Recommendation Report for Planning Permission**REF NO:** R/225/13/**LOCATION:** Sainsburys Supermarkets Ltd, Unit C
New Road
Rustington Littlehampton**PROPOSAL:** Installation of transformer, generator, substation, sprinkler tank and pump house at ground floor level along with rooftop condenser units.**SITE AND SURROUNDINGS**

RECOMMENDATION

REFUSE

Sprinkler Tank and
Pump House details

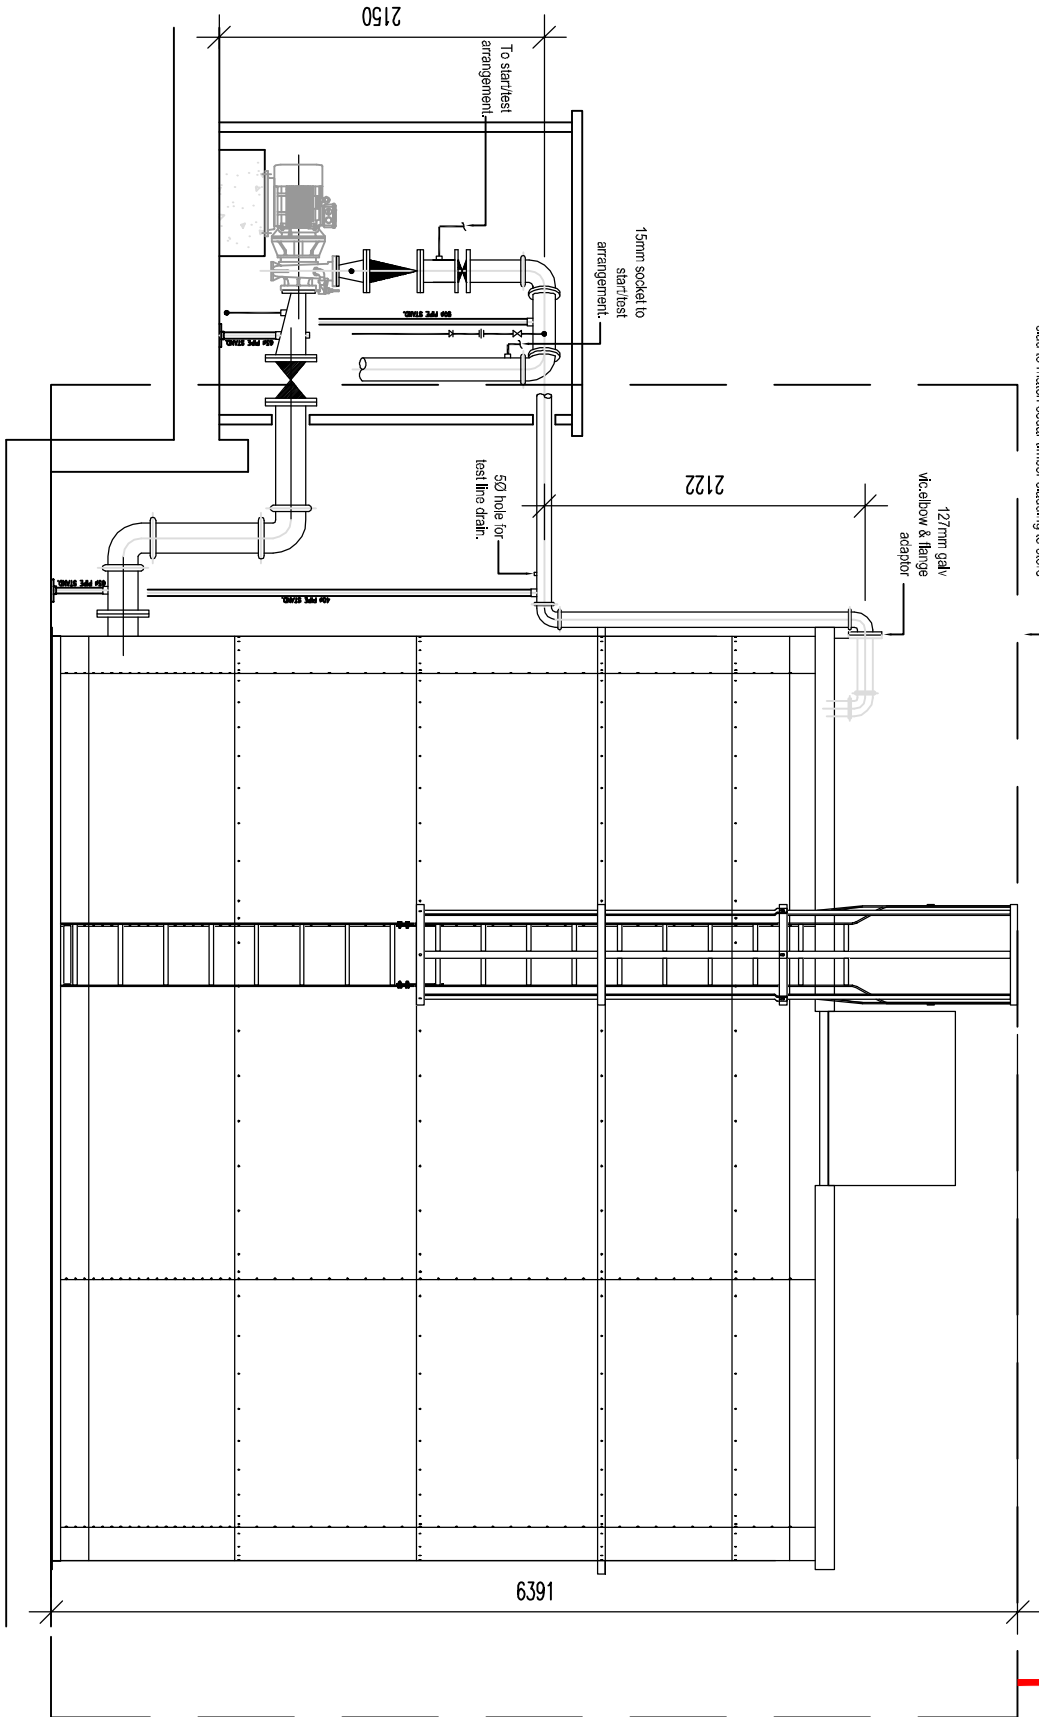
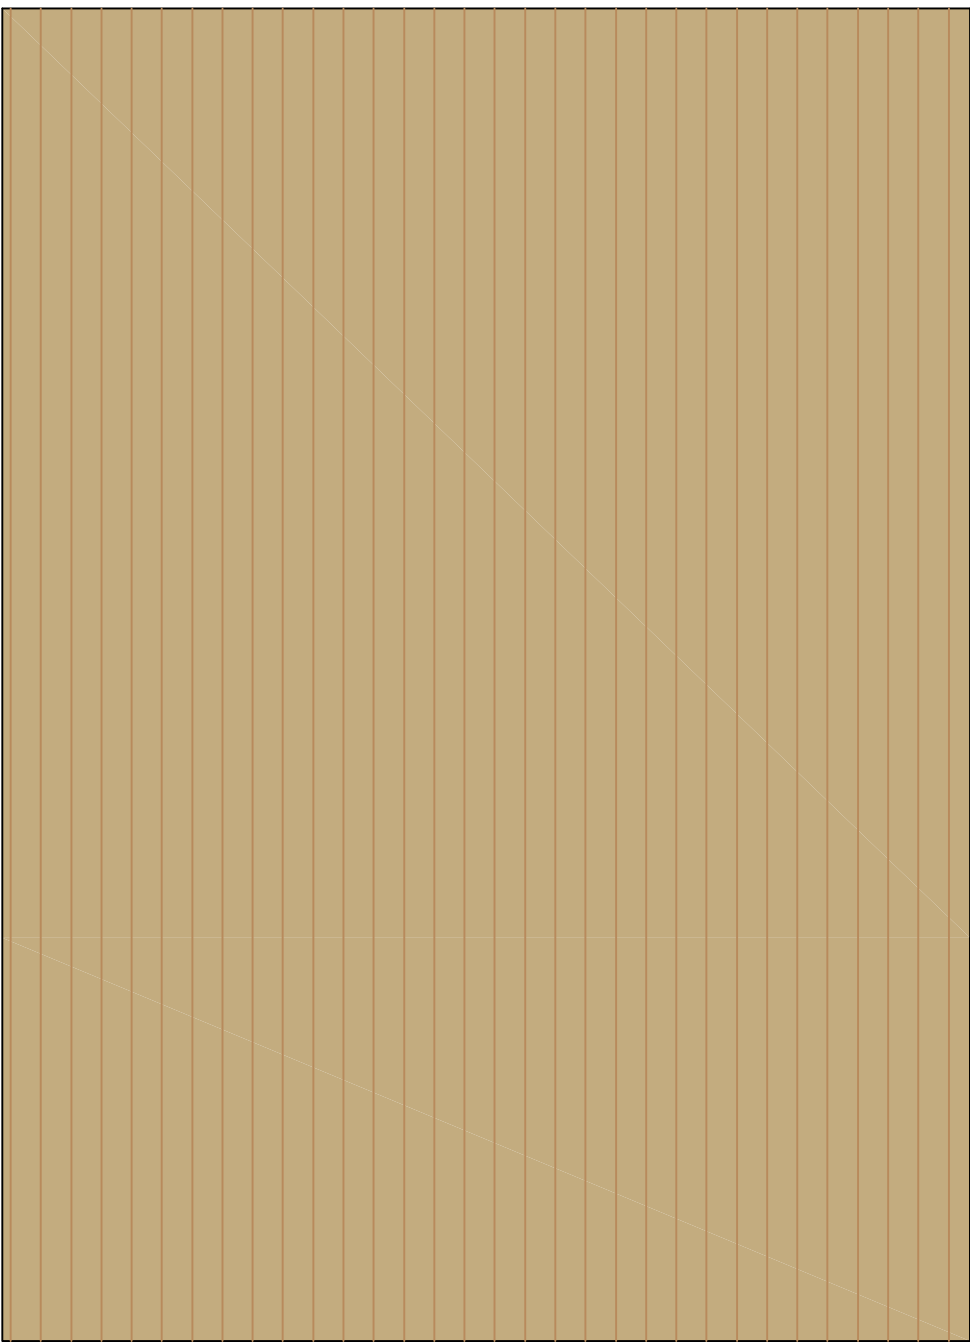
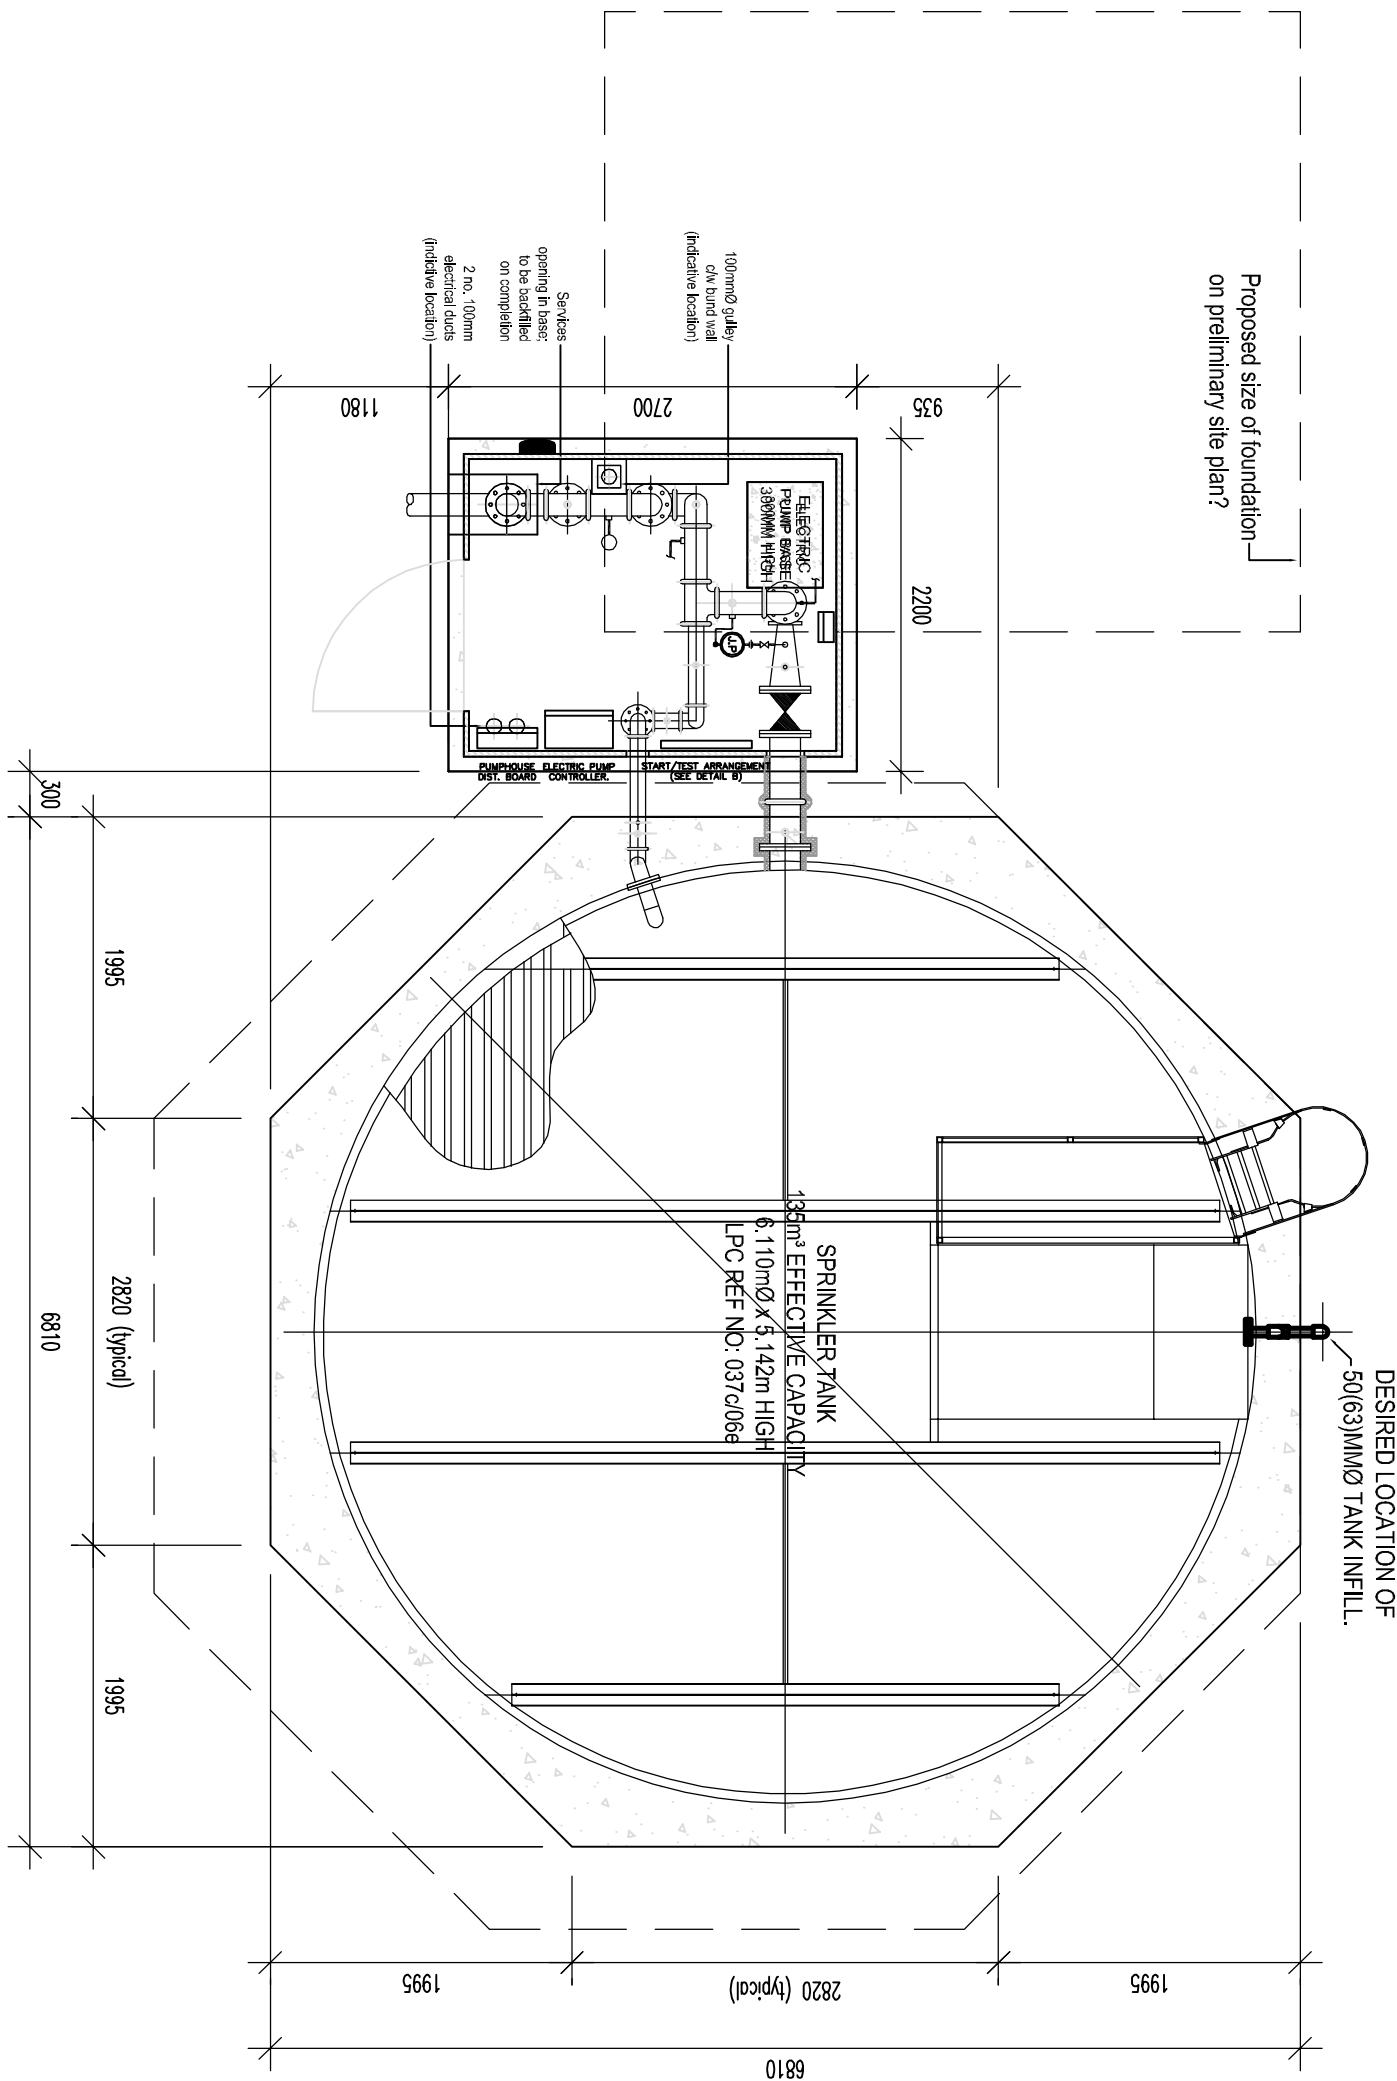
This aspect of the proposal was previously refused due to the impact of the metal tank on the character and appearance of the area and as it was out of character and harmful on the street scene.

The proposed sprinkler tank and pump house occupies a very prominent position at the north east corner of the site relative to the public realm. The sprinkler tank was also visible from nearby properties and residences in the adjacent Darlington Court.

The sprinkler tank measures approximately 6.4 metres tall. It is untreated grey galvanised steel, giving the structure an industrial appearance.

Following refusal of planning permission R/140/12 the applicants erected a wooden palisade screening surrounding the proposed sprinkler tank. The palisade fence on plan is trapezoid in shape and measures approximately 6.5 metres tall, and 10 metres in width when fronting onto the A259 "New Road". The applicants highlights that the palisade fencing matches the wood cladding used in the retail store and that this contributes to conformity.

The proposed wooden palisade fence takes up a significantly greater area surrounding the sprinkler tank than shown on the proposed plans. The fencing appears uneven in height and is untreated wood which leaves the wooden fence appearing to be temporary in nature.

Overall, it is considered that the proposed screening is of poor quality design, relates poorly to the redeveloped store, and remains visually prominent.

In conclusion, it is considered that the sprinkler tank with fencing is visually incongruous and out of place in the local street scene. It is of significant scale and is not sufficiently screened from the accessible public realm. The sprinkler tank damages the established character of the area in contrast with policy GEN7 of the Arun Local Plan 2003 and is therefore recommended for refusal.

- 1 The proposed sprinkler tank and pump house is located in a prominent position adjacent to a main thoroughfare. By reason of its scale, bulk and finish it will result in a form of development that will have a significantly adverse impact on the visual amenities of the location and character of the area contrary to Policy GEN7 of the Arun District Local Plan

DRAWING
Proposed Plant
Transf./Generator

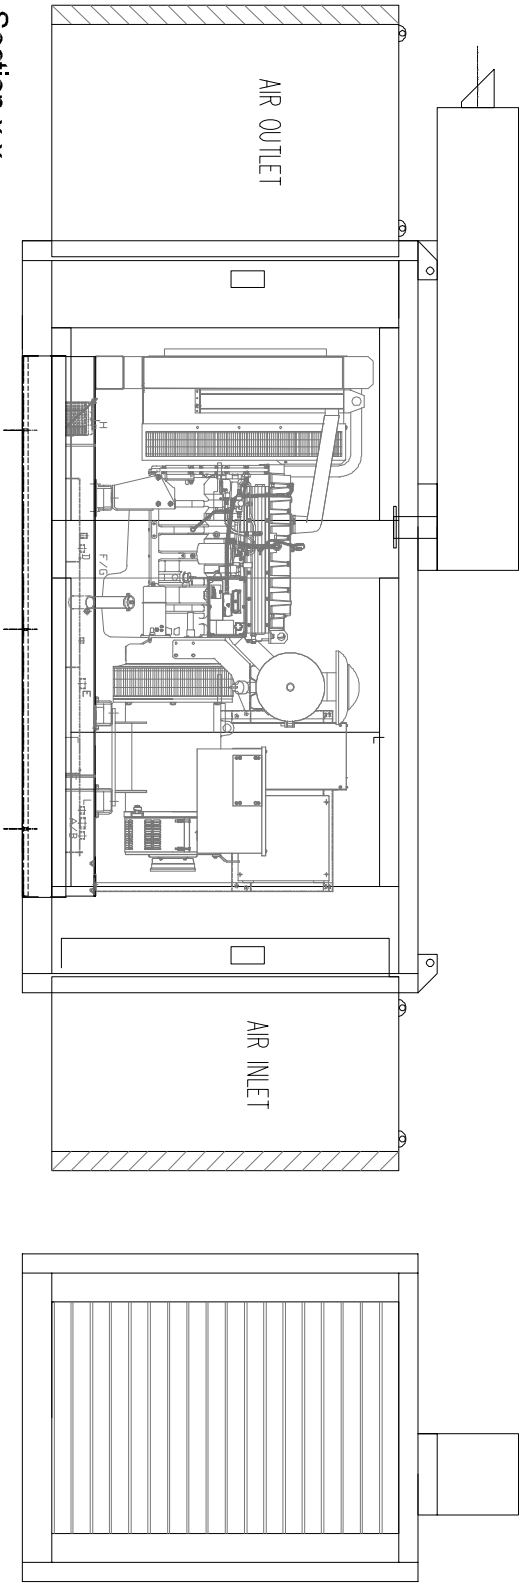
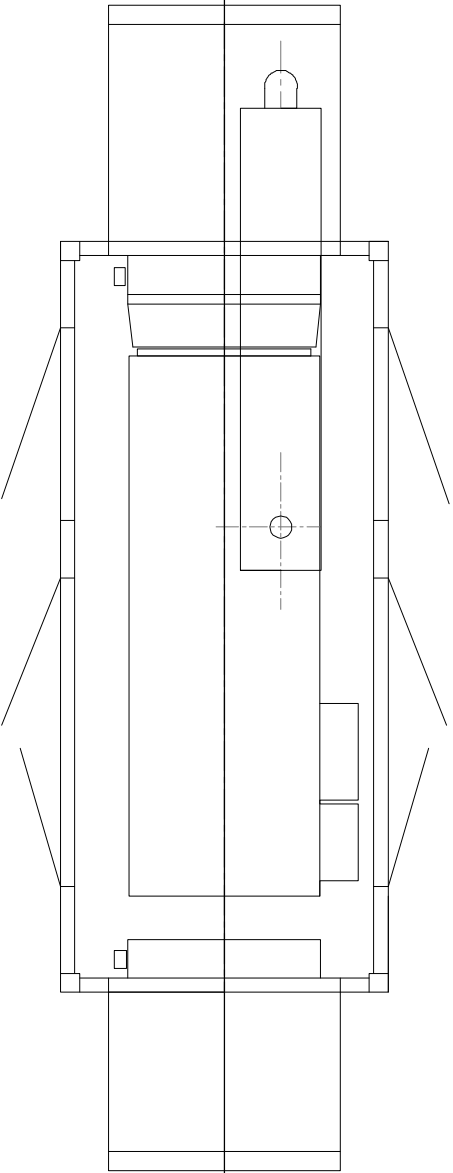
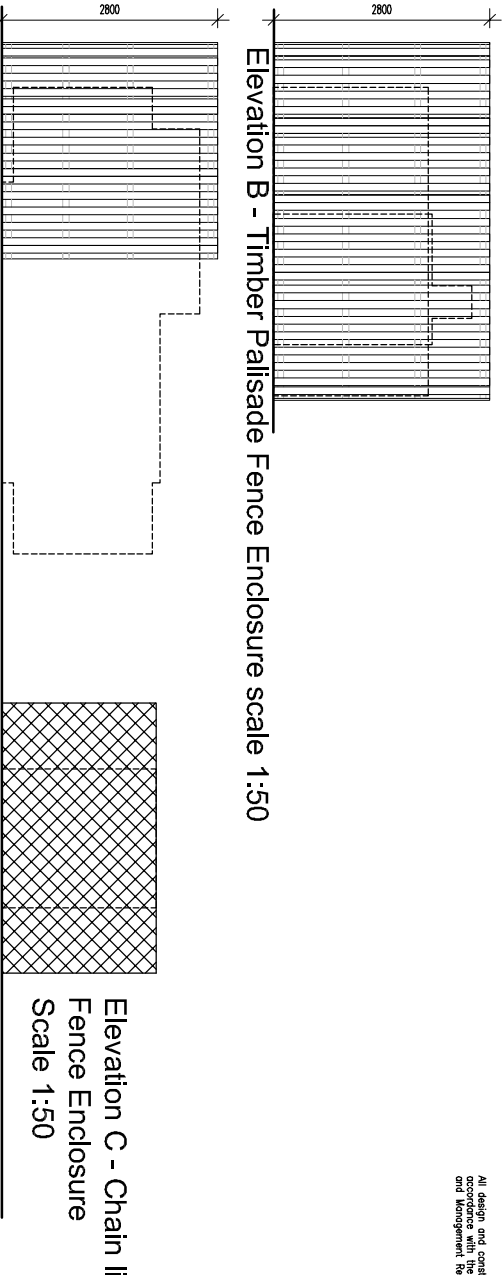
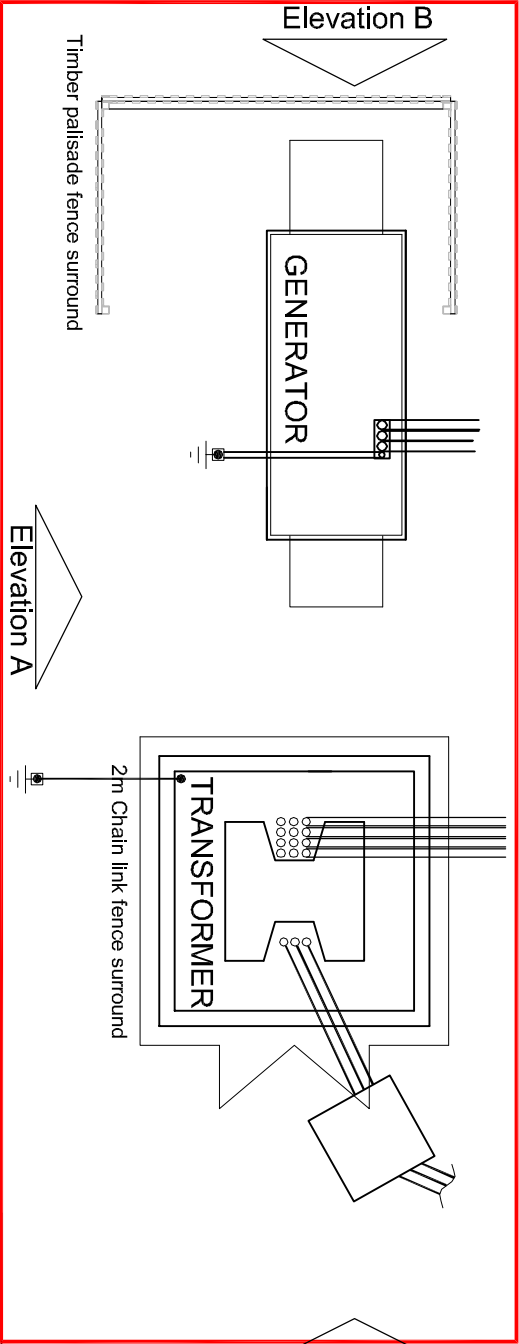
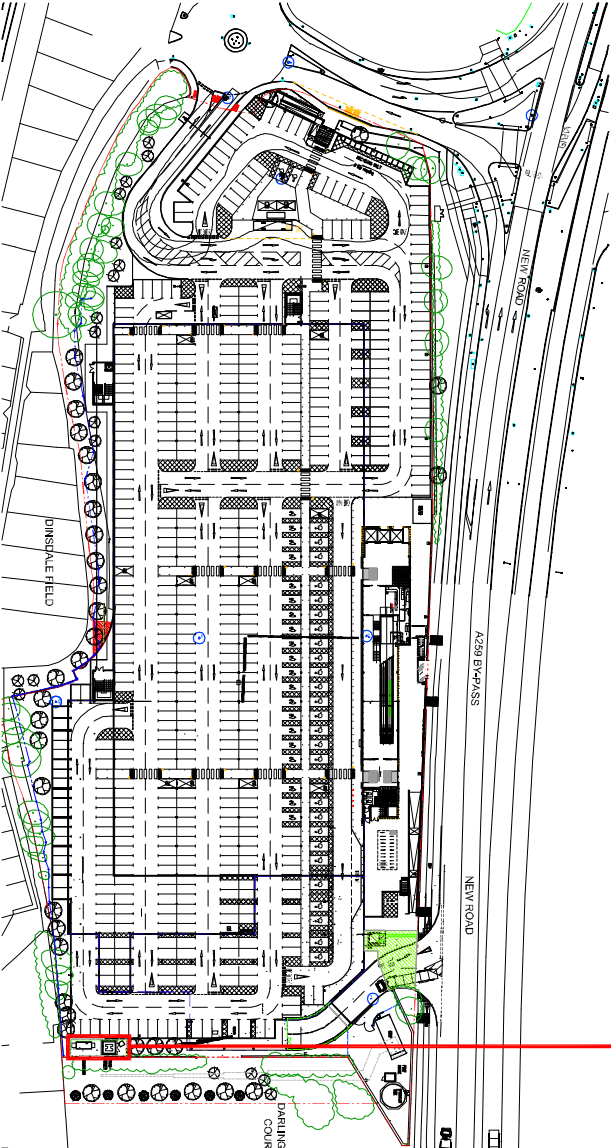
A transformer and generator is proposed in the south eastern boundary on the ground floor, enclosed by a hit and miss timber fence.

The proposed transformer and generator are immediately visible from a number of adjacent residential curtilages along Burmill Court and Angmering Way. The proposed transformer and generator are proposed to be housed in a hit and miss timber fence enclosure measuring 2.8 metres tall, 14.75 metres long and 4.6 metres wide.

It is not considered that the proposed transformer and generator will be visible from a number of residences and given the size and scale of the proposal will have an unacceptable impact on the character of area.

A number of local residents have expressed concerns through their letters of representation that the generator and transformer will generate significant amounts of noise. It is located in close proximity to a number of residences along Angmering Way.

The transformer and generator are proposed as back up energy supplies for when there are electricity cuts and as such their use will be limited and short term. The applicants have submitted a noise assessment that identifies that noise levels will be within a reasonable range and will not have a materially adverse impact when it is operational.

It is therefore considered that the transformer and generator are compliant with Policy GEN7 in terms of visual amenity and that they are not likely to be contrary to policy GEN32 in terms of the noise impact of the proposal.
